**Subject: Newstan Colliery (DA 73-11-98) - Modification 8**

**Request for comments - Lake Macquarie City Council**

Our Ref: MISC/81/2010/A

Attachment 2: Revised EA Figure 2-6

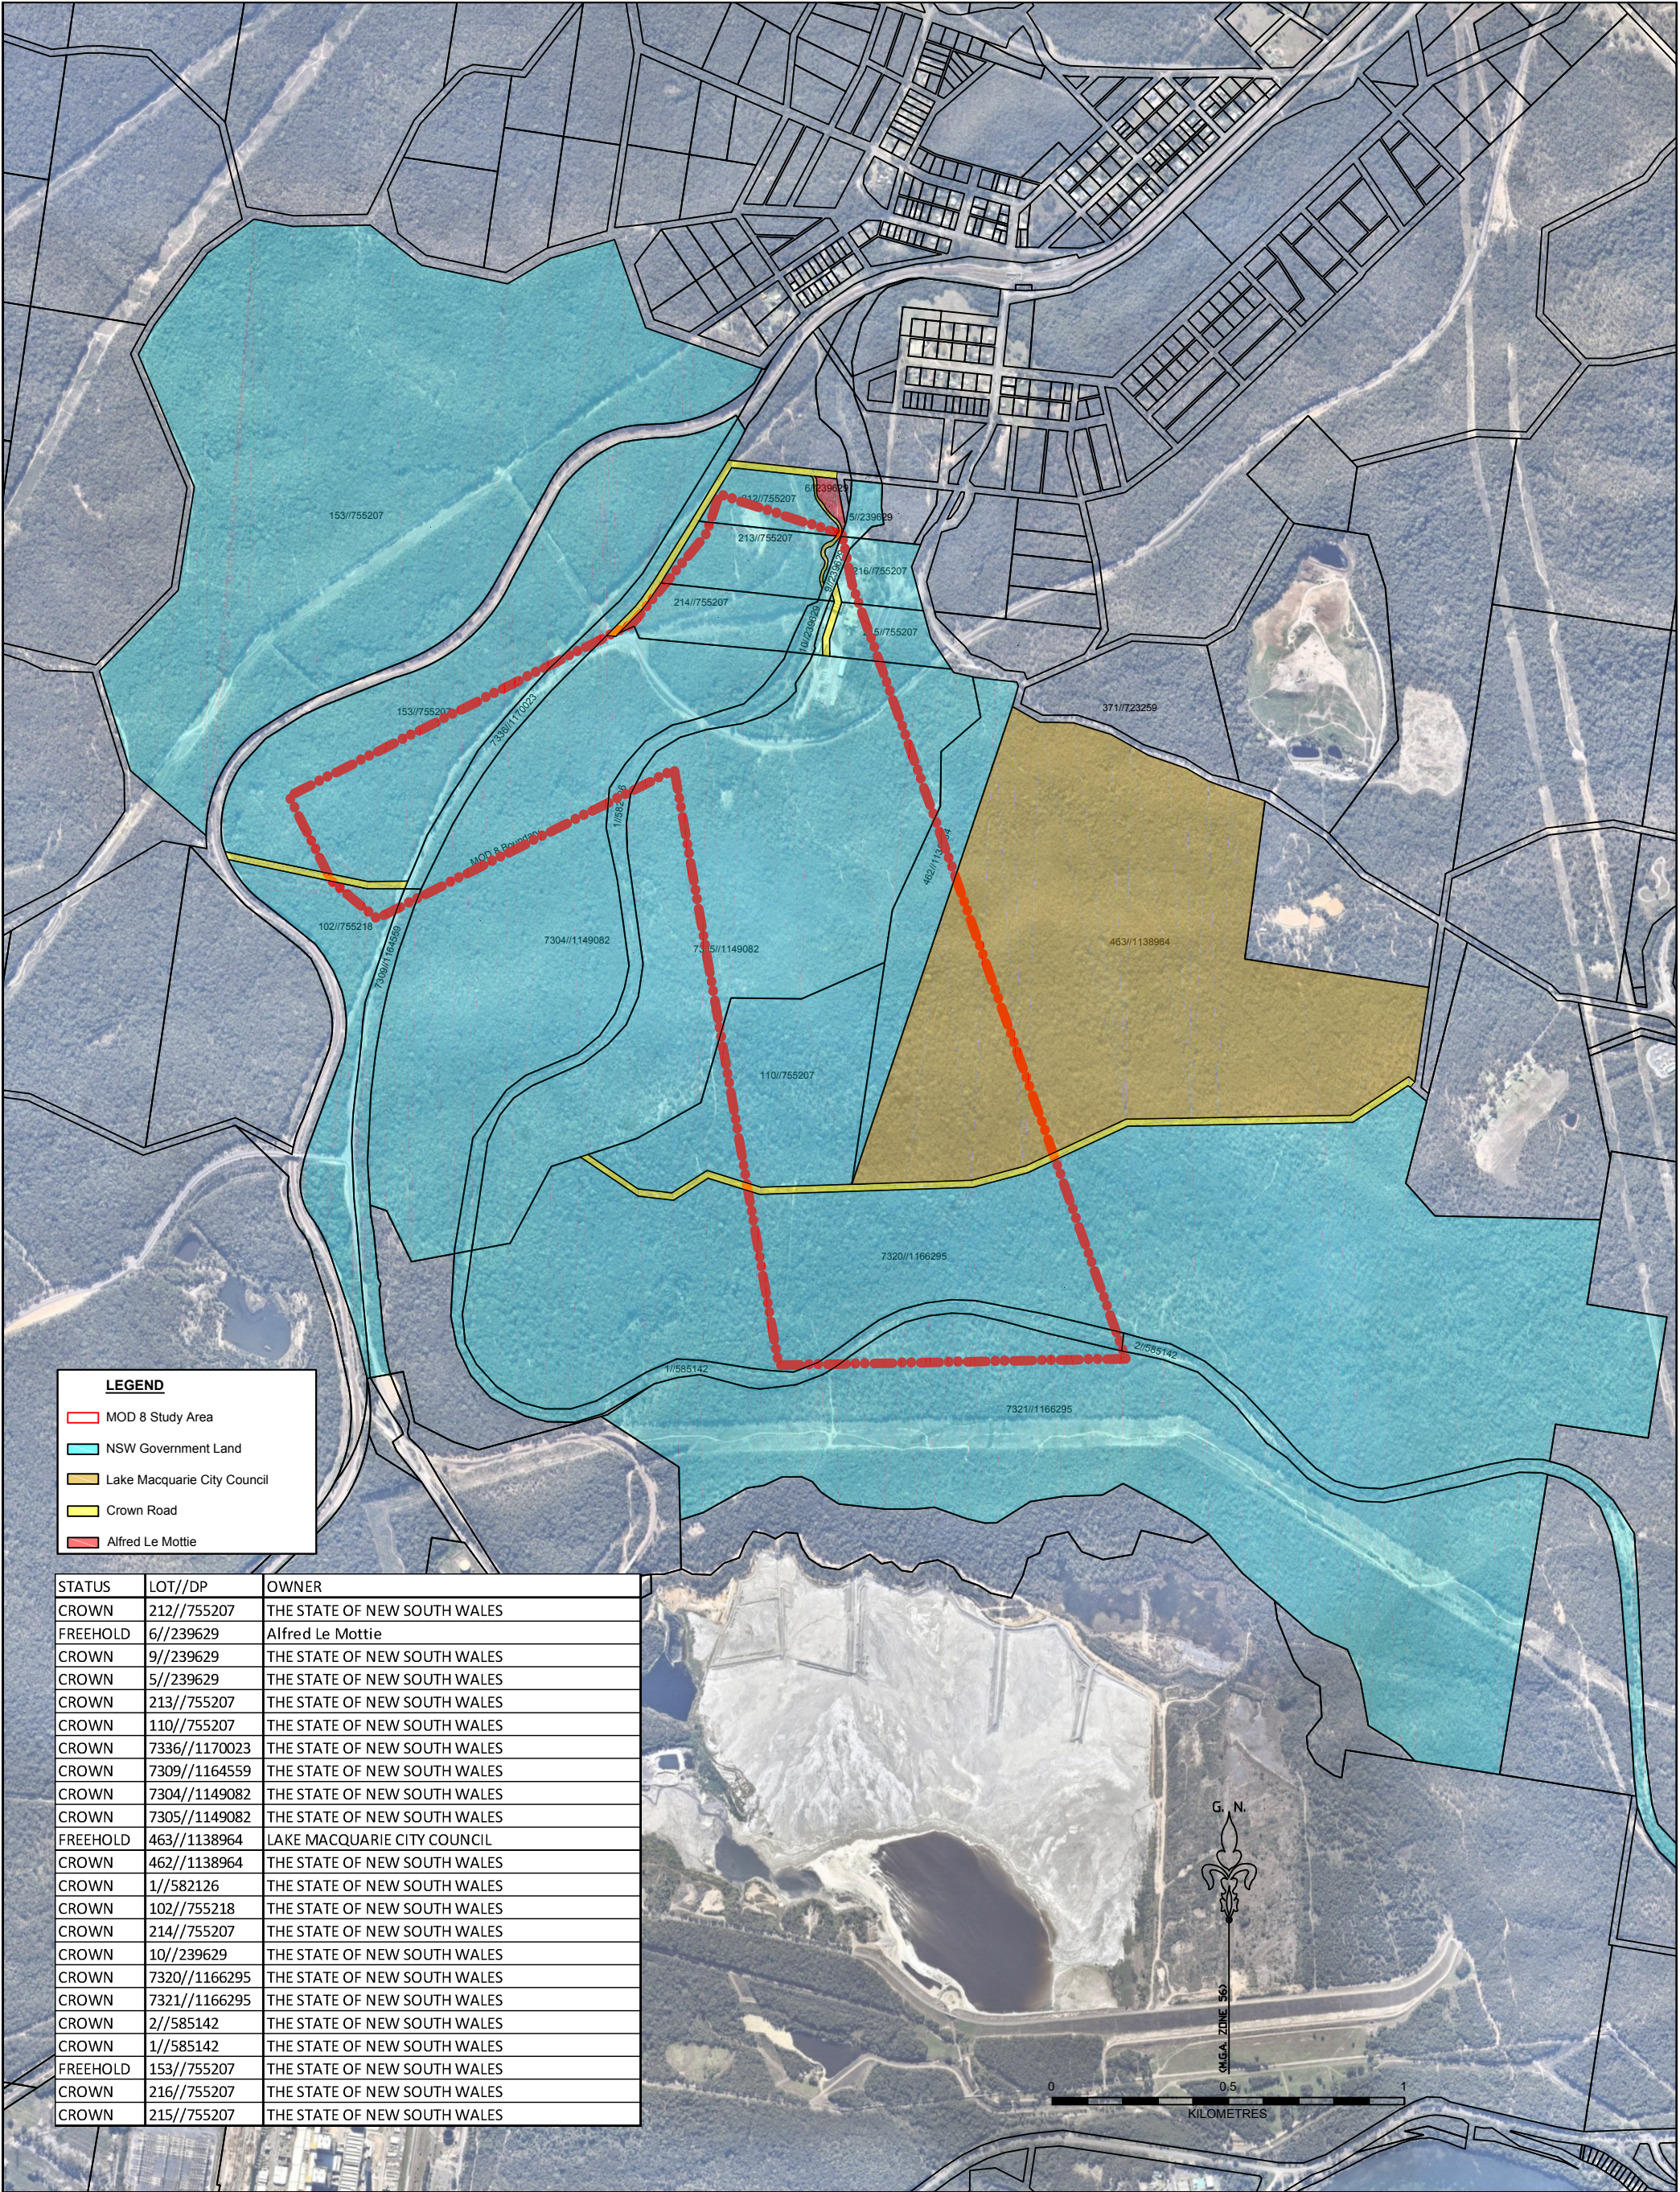
Land owned by Lake Macquarie City Council is partly within the project area. This land is described as Lot 463 DP 1138964 and is incorrectly shown in the environmental assessment (Figure 2-6) as being owned by the NSW Aboriginal Land Council.
